Householder Proforma

Application Ref: 2021/1217
Address: 13 Upper Sheffield Road, Barnsley, S70 4PW
Neighbour Representations: No
Property Description: the red brick semi detached property is located on Upper Sheffield Road, a predominantly residential area characterised by red brick, semi detached and terraced properties. The dwelling benefits from a two storey mono pitched roof which forms part of the original dwelling.

Proposed Extension: Erection of single storey rear extension following the removal of the existing outbuilding

Ground Floor Plan
As Proposed

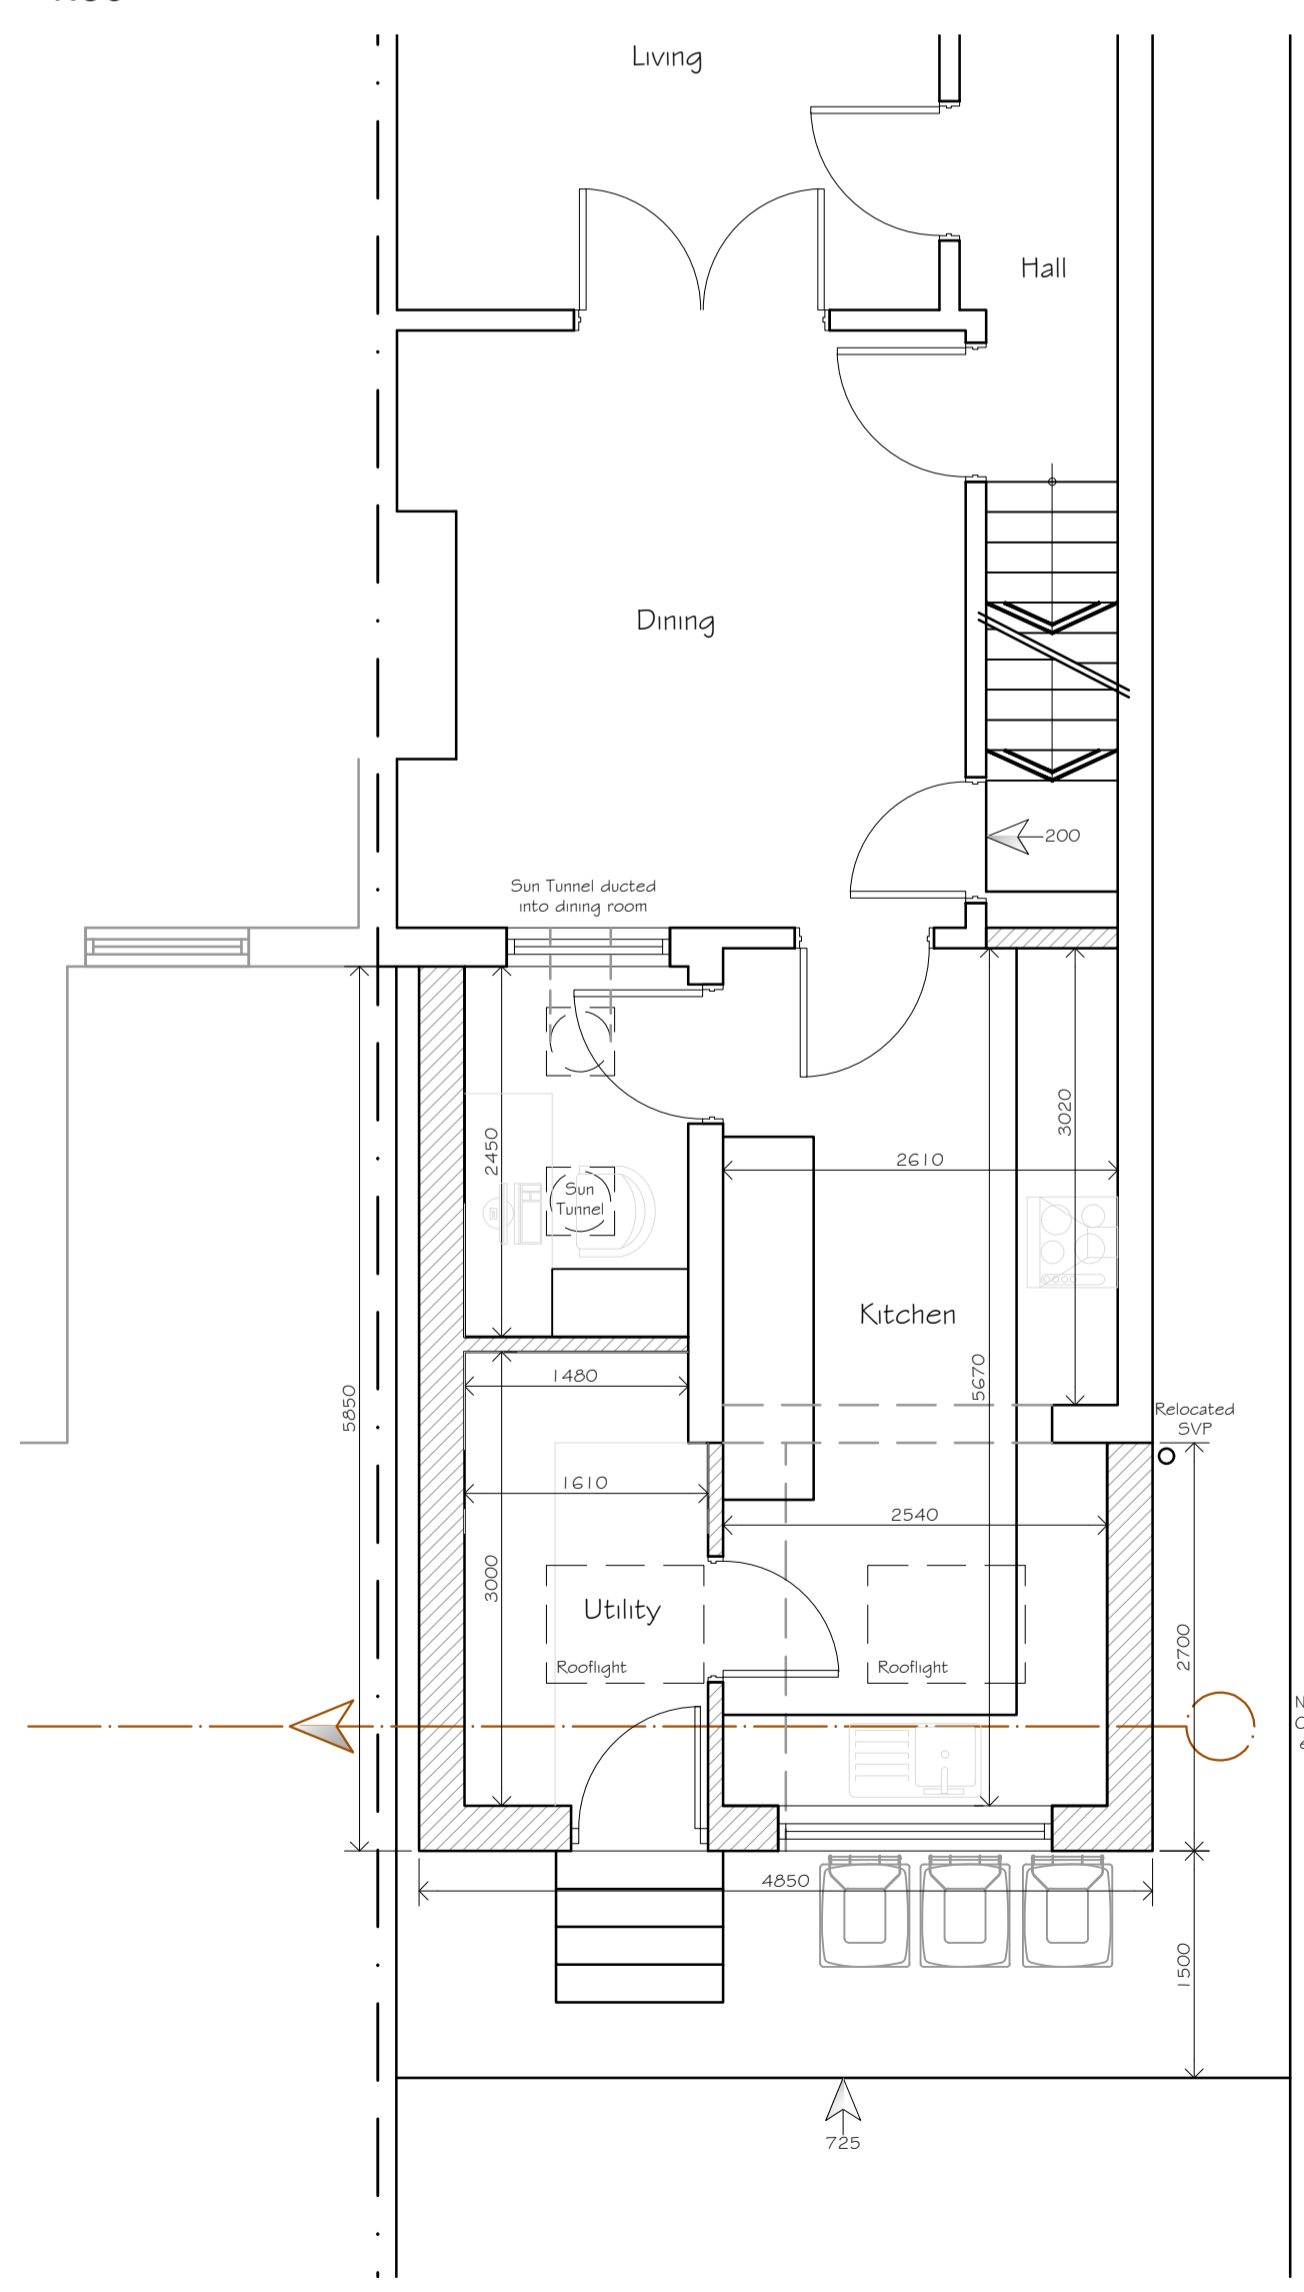
The applicant seeks permission for the erection of a single storey rear extension to wrap around the existing two storey rear projection which forms part of the original dwelling.

The proposed extension is to project 5.8m from the rear elevation of the dwelling, reducing to 2.7m from the rear elevation of the original rearwards projection.

Side Elevation
As Proposed

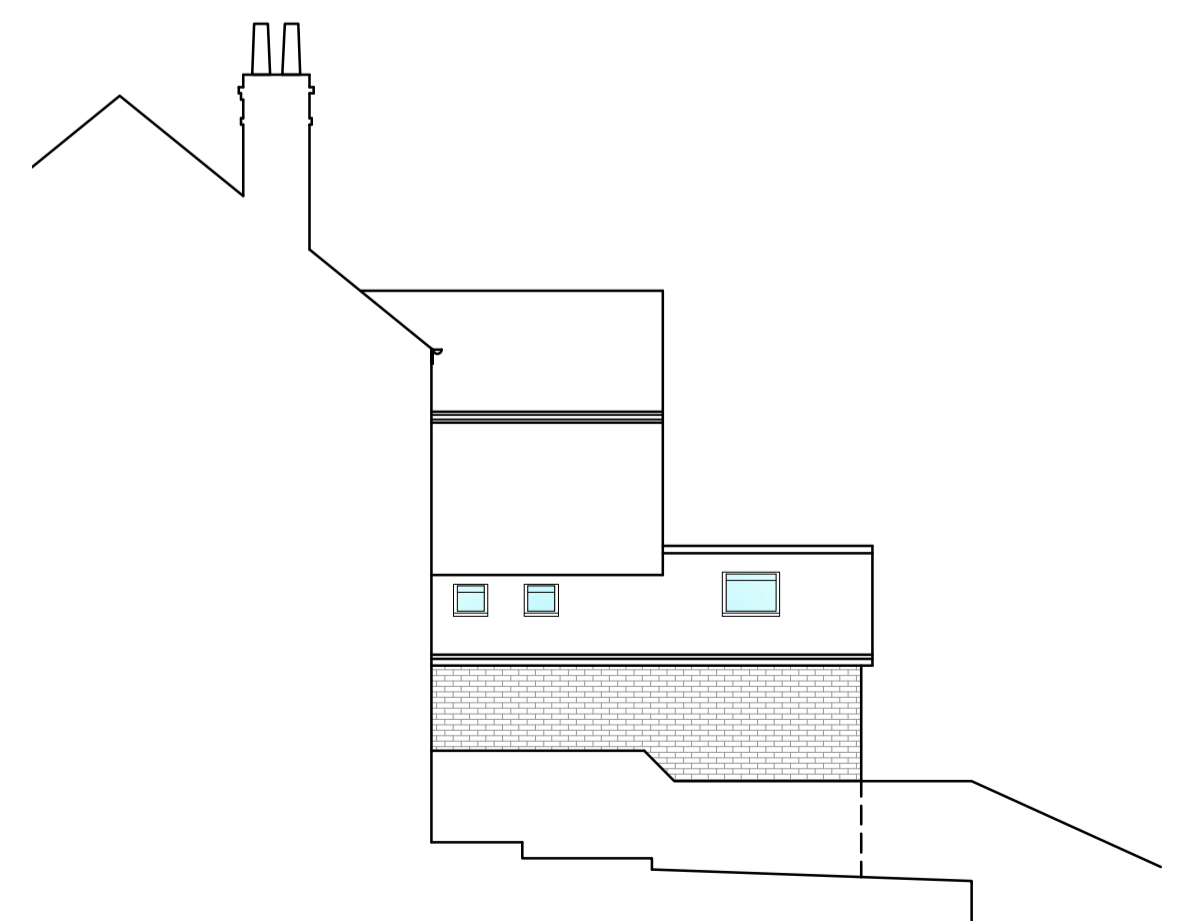
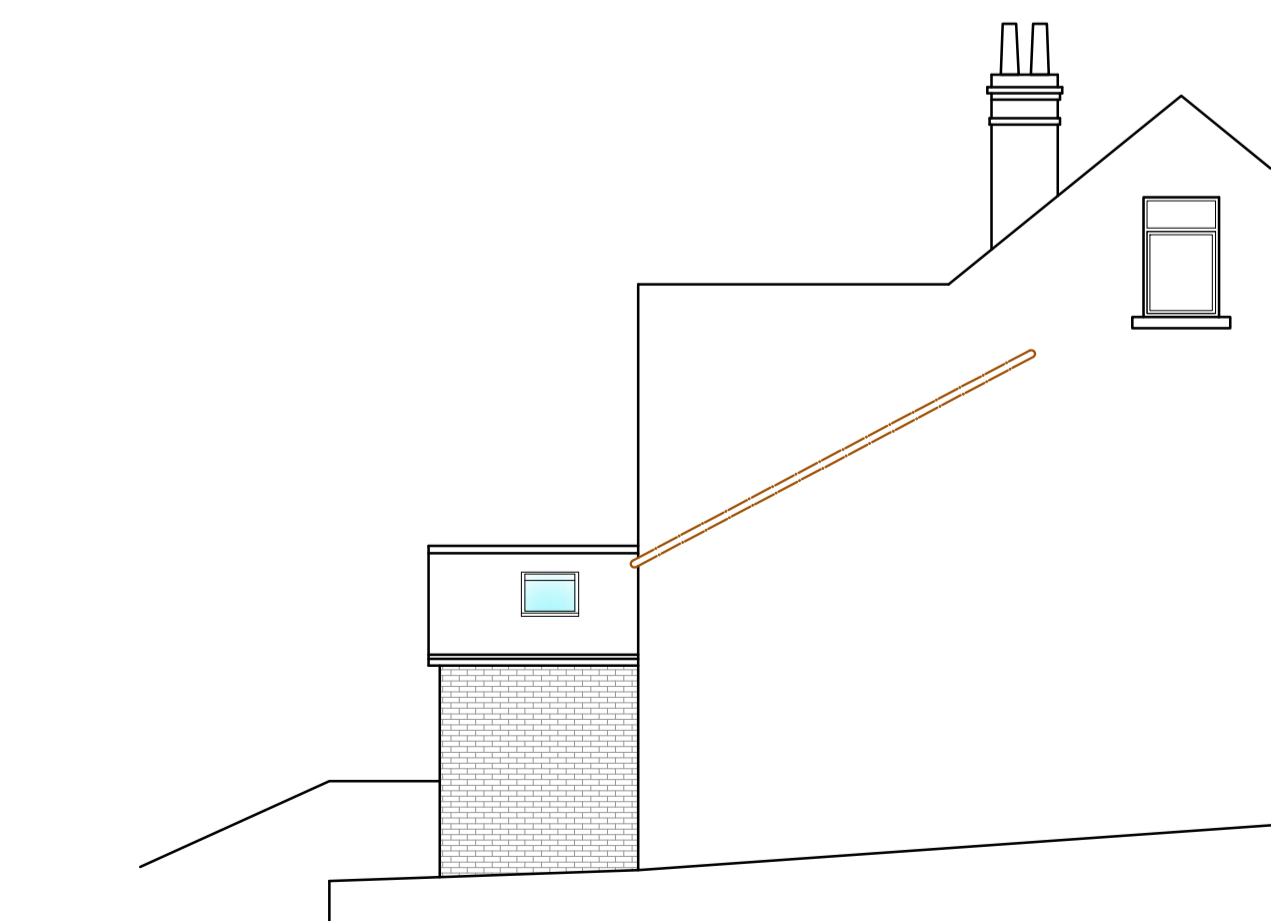
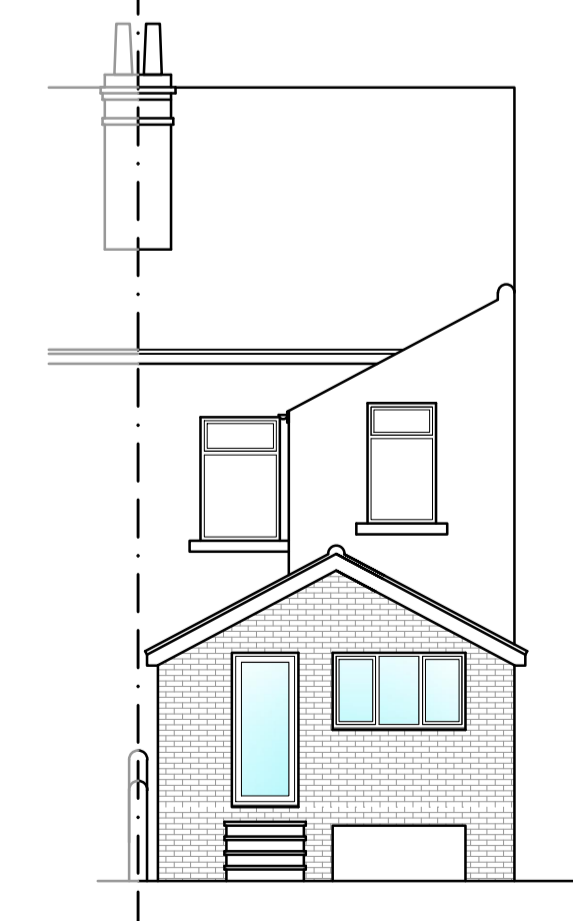
It is acknowledged that the overall projection of 5.8m falls outside of the guidance set out in the Supplementary Planning Document – House Extensions and Other Alterations, however at 5.8m the projection falls within the parameters of the Larger Home Extensions set out in the General Permitted Development Order. The parameters also set out a maximum eaves height of 3m with an overall height not exceeding 4m.

The proposed extension falls within the parameters of the Larger Home Extensions with the exception of the ridge height exceeding 4m by 0.25m, it is considered that the extension is acceptable and the additional is not sufficient to warrant refusal of the application given that no objections have been raised to the scheme and should the height be reduced by 0.25m would not require planning permission.

The rear extension is deigned to harmonise with the original dwelling in terms of roof style and pitch and it is proposed to construct the extension from materials which match the original dwelling.

There are no windows proposed on the side elevations of the extension and those located on the rear elevation, whilst at ground floor level are located approximately 10m from the rear boundary.
